From:
To: [DCAdmin](#)
Subject: 2021/93621
Date: 01 April 2023 08:25:04

Please consider my comments regarding this proposed development.

Description: PROPOSED SITE PLAN & 3D VIEW

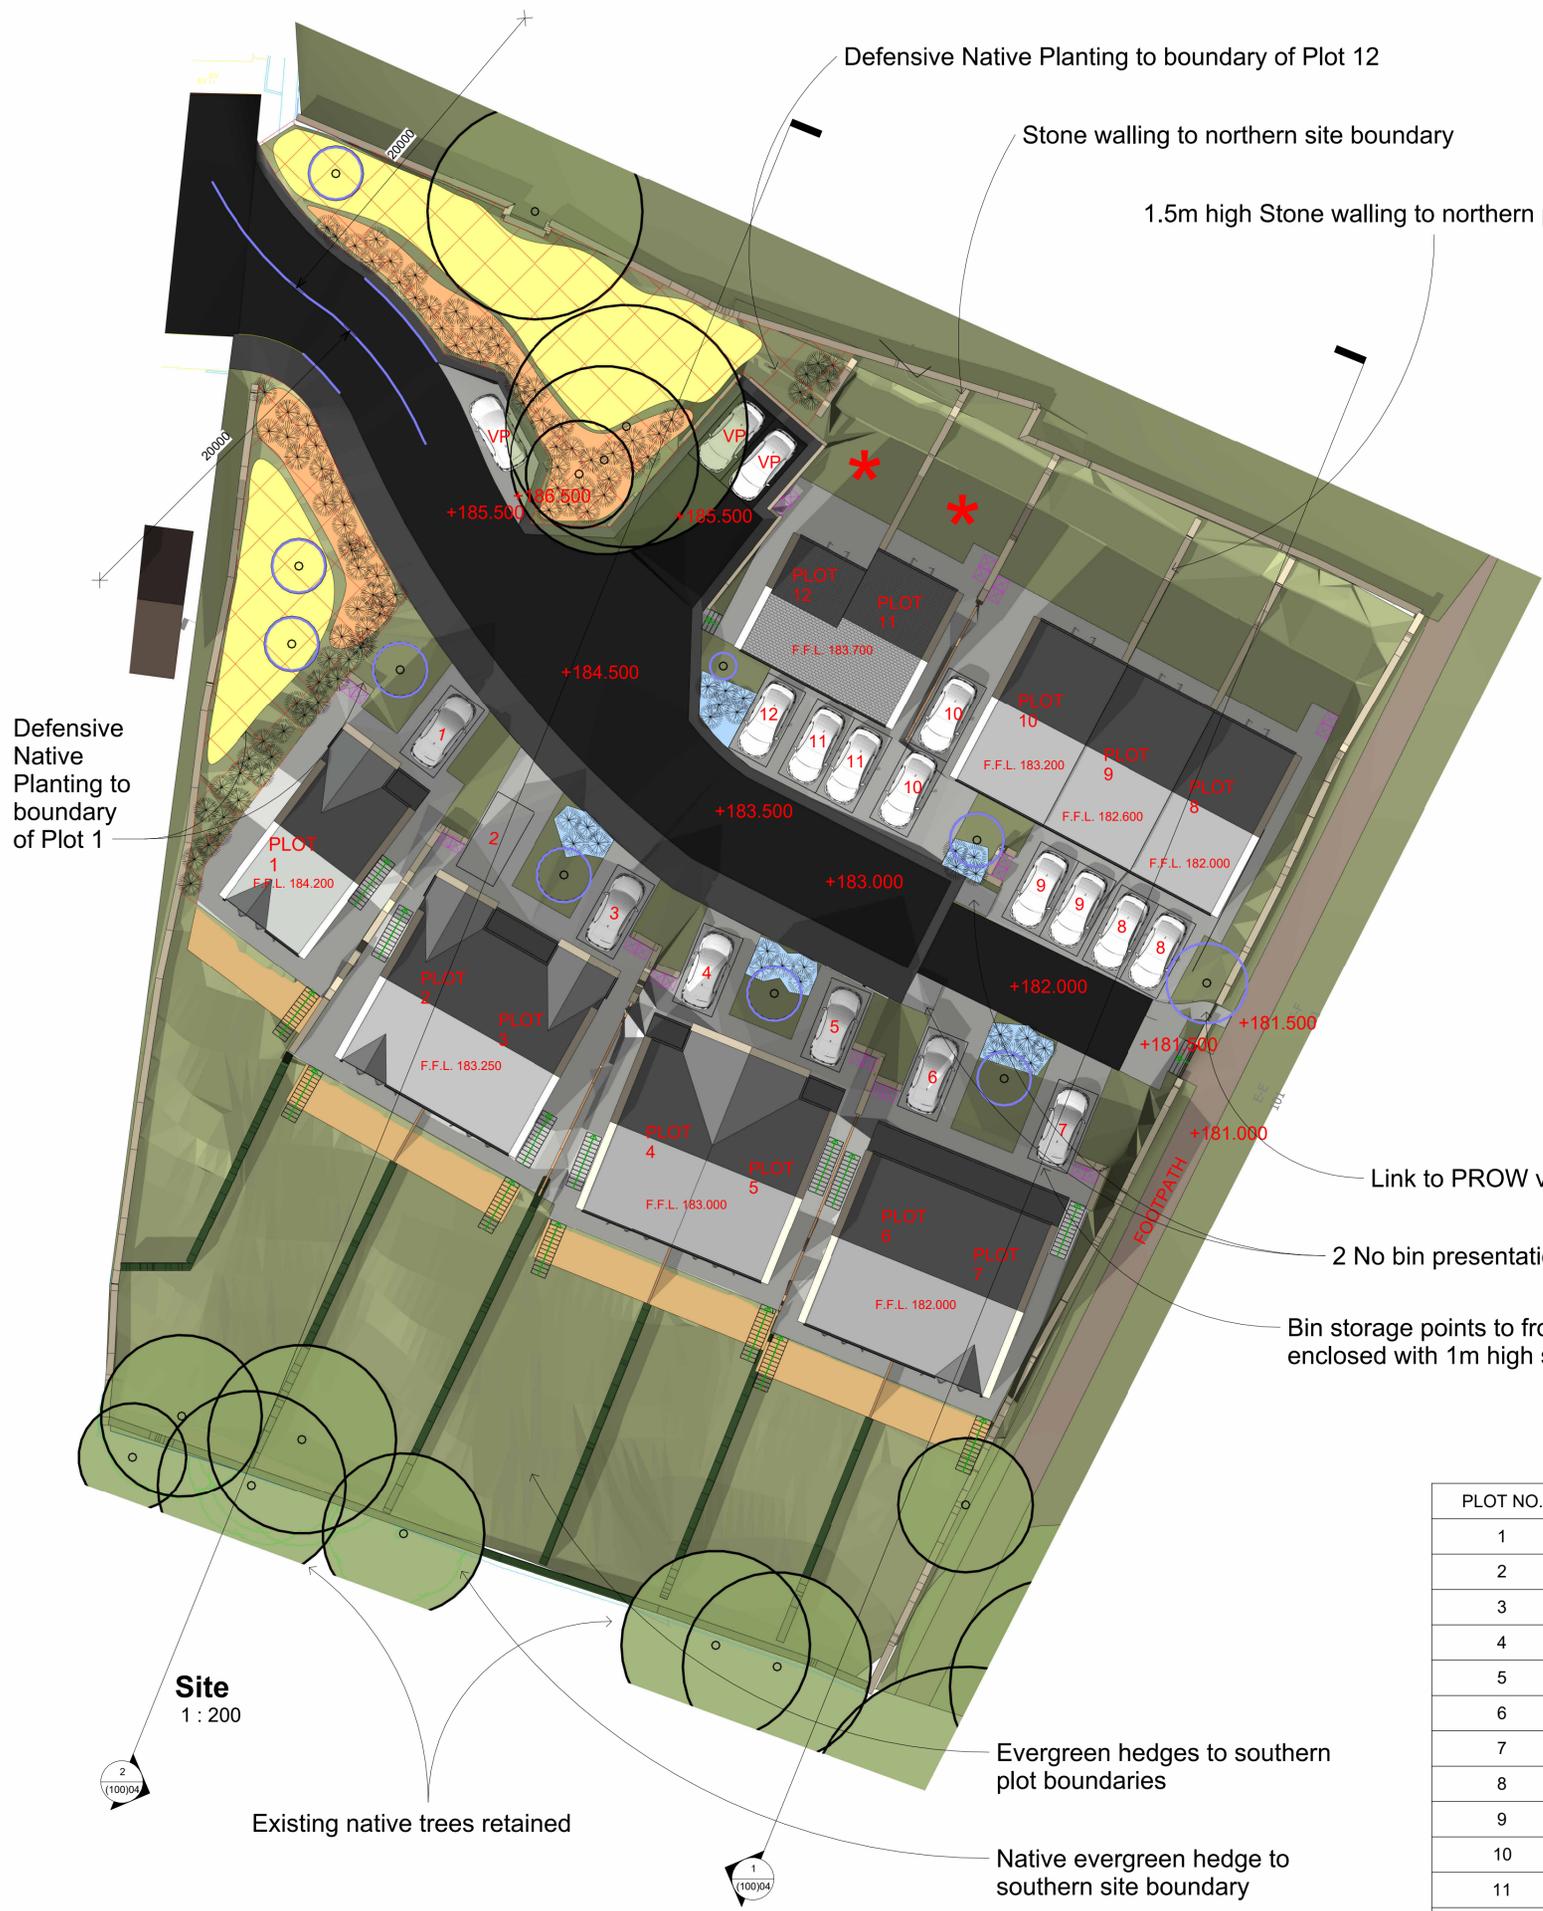
7. The local schools are over subscribed. Additional families will add to the strain.
8. There is a constant struggle with parking at Fullwood Drive. Residents park on the road leaving issues with access. The proposals remove parking spaces from the end of Fullwood Drive and this will add to the strain.
